Our ref: SSD-8482905
Senders ref: DOC20/619770

Subject: Request for input into Secretary's Environmental Assessment Requirements - Moama Ethanol Plant (SSD-8482905)

The BCD has reviewed the Scoping Report (version 2 dated 28 July 2020) for this proposal and provides SEARs for the proposed development in **Attachment A**. Guidance material is listed in **Attachment B**.

INDICATIVE SITE LAYOUT

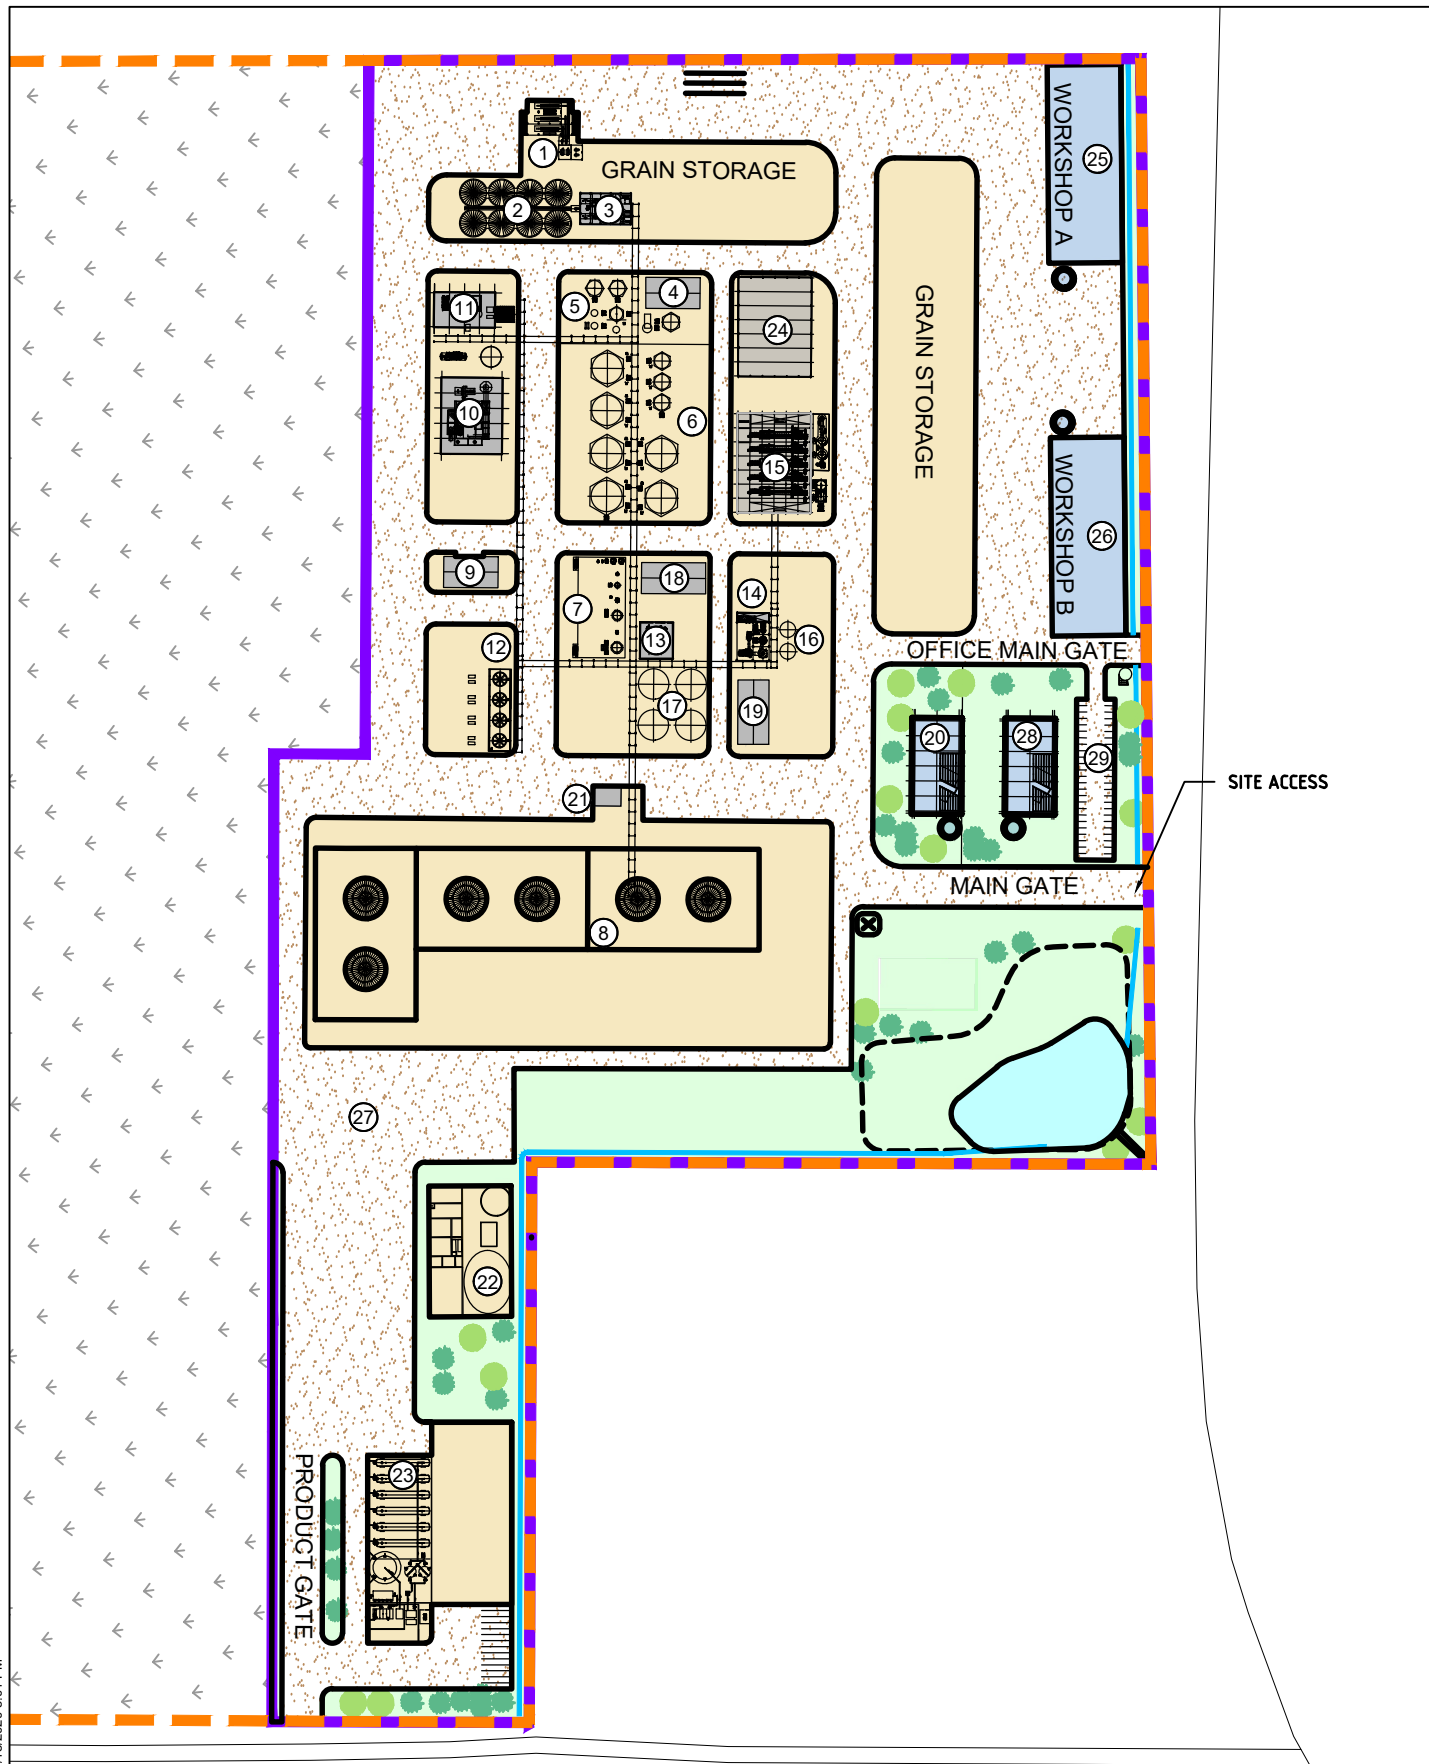
We understand that while the indicative site layout is known, its exact location is not. Similarly, from the information provided, it is evident that the access points to the site have not been decided. Scattered paddock trees exist on the subject land and land identified on the Biodiversity Values Map exists along the extent of the eastern boundary along the Cobb Highway.

Attachment C of the Scoping Report does not give the location of the indicative site layout relative to the subject land, nor does it show access points to the site. Attachment C does not demonstrate that the proposal will have no impact on threatened species in the area because the location of proposal has not been finalised. Attachment C does not identify category 1 land consistent with the definition established by ss.60H of the *Local Land Services Act 2013*. Category 1 land may be disregarded from the assessment of biodiversity impacts consistent with ss.6.8 of the *Biodiversity Conservation Act 2016* (BC Act). The applicant should seek endorsement of the method used to determine category 1 land from the BCD before it is disregarded.

The EIS should demonstrate category 1 land, the location of the indicative site layout relative to the scattered paddock trees on the subject land, and the location and design of access points relative to the roadside vegetation mapped on the Biodiversity Values Map. The avoidance of that vegetation, the disregarding of category 1 land, and any loss or fragmentation of fauna habitat should be documented in a Biodiversity Development Assessment Report (BDAR).
